EPC STORMWATER REVIEW COMMENTS
IN ORANGE BOXES WITH BLACK TEXT

EL PASO COUNTY GRADING AND EROSION CONTROL PLAN CHECKLIST

PPR246

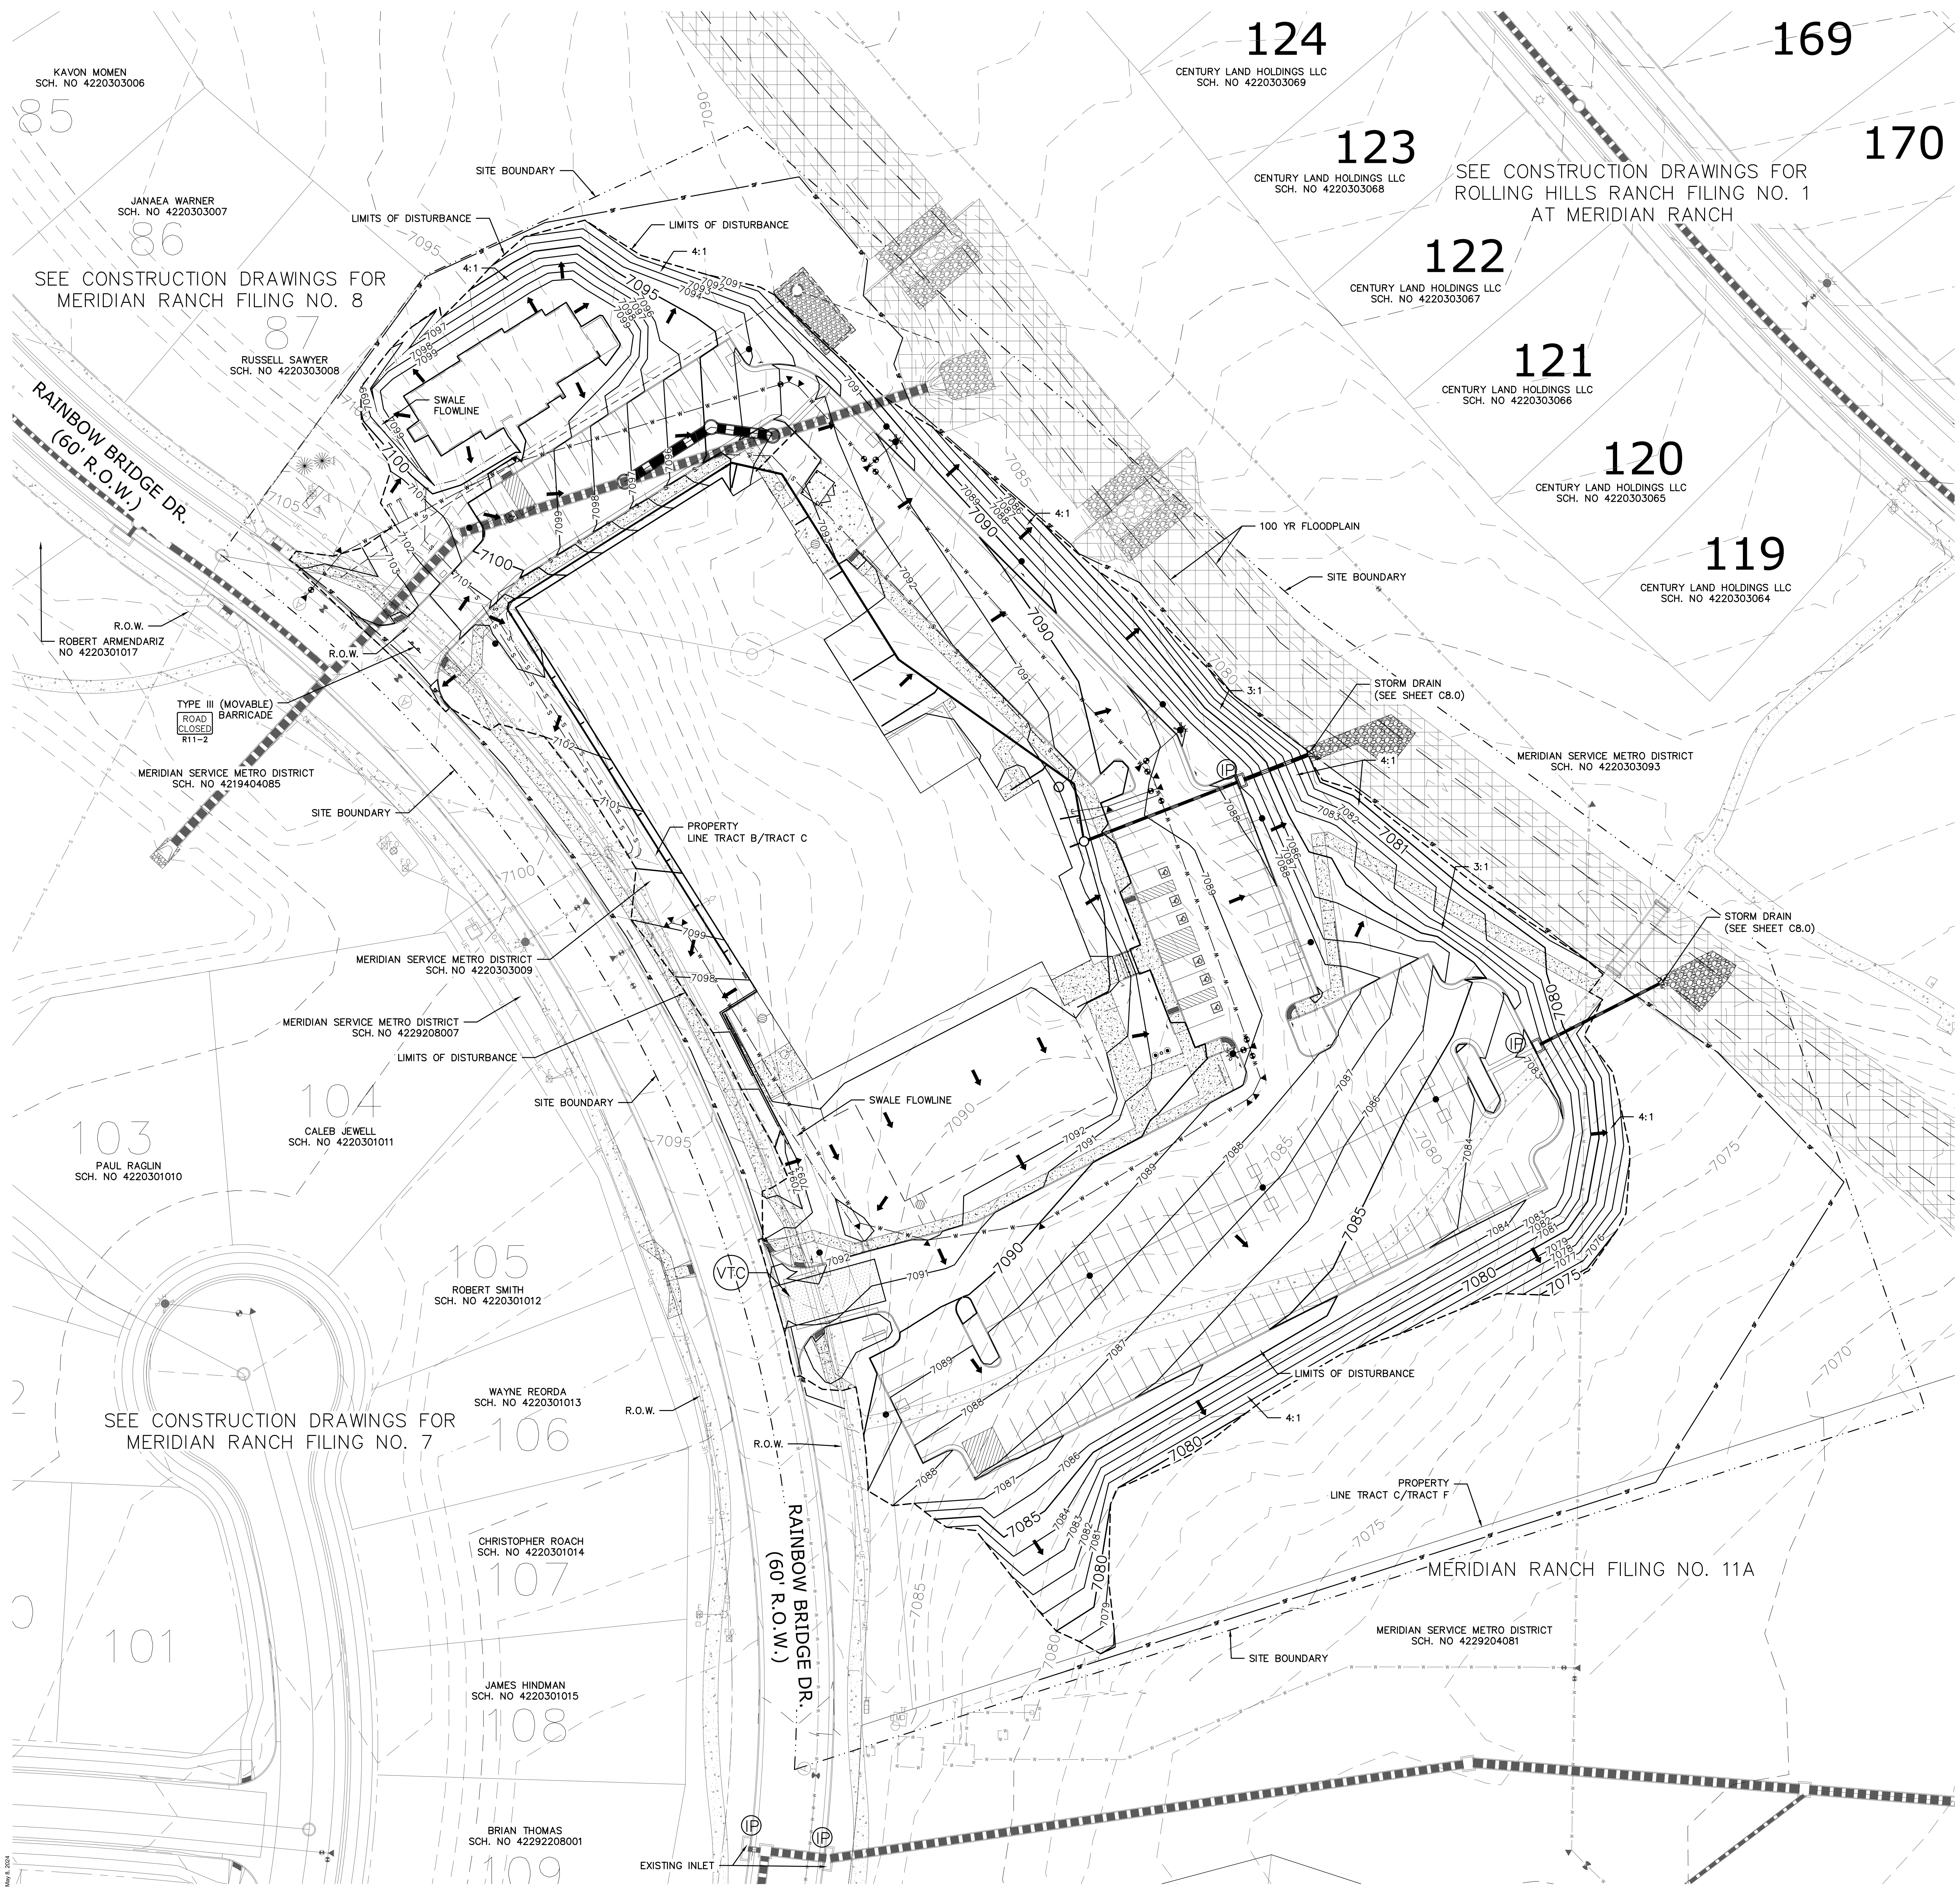
l	Existing and proposed contours 2 feet or less (except for hillside)		Y
m	Limits of disturbance delineating all anticipated areas of soil disturbance as shown		N
n	Identify and protect areas outside of the construction site boundary with construction fencing or other methods as appropriate Construction fencing not proposed		N
o	Off-site grading clearly shown and called out		N/A
p	Areas of cut and fill identified		Y
q	Conclusions from soils/geotechnical report and geologic hazards report incorporated in grading design (slopes, embankments, materials, mitigation, etc.)		Y
r	Proposed slopes steeper than 3:1 with top and toe of slope delineated. Erosion control blanketing or other protective covering required		N/A
s	Stormwater flow direction arrows		Y
t	Location of any dedicated asphalt / concrete batch plants		N/A
u	Areas used for staging, storage of building materials, soils (stockpiles) or wastes. The use of construction office trailers requires PCD permitting		Y

v	All proposed temporary construction control measures and non-structural. Temporary sedimentation to include "initial," "interim," and "final" or shown on separate phased maps identifying each phase Historically, a table has been accepted for the phases. no change to the plans		N
w	Vehicle tracking prevention and/or signage provided at access points not to be used for construction barricade added at second driveway access		N
x	Temporary sediment ponds provided for disturbed drainage areas greater than 1 acre N/A		N

The plans do not show locations of diversion, pumps, discharge location etc. If anticipated provide

Pond D is under the direct ownership of the owner, correct? Wouldn't this be N/A?
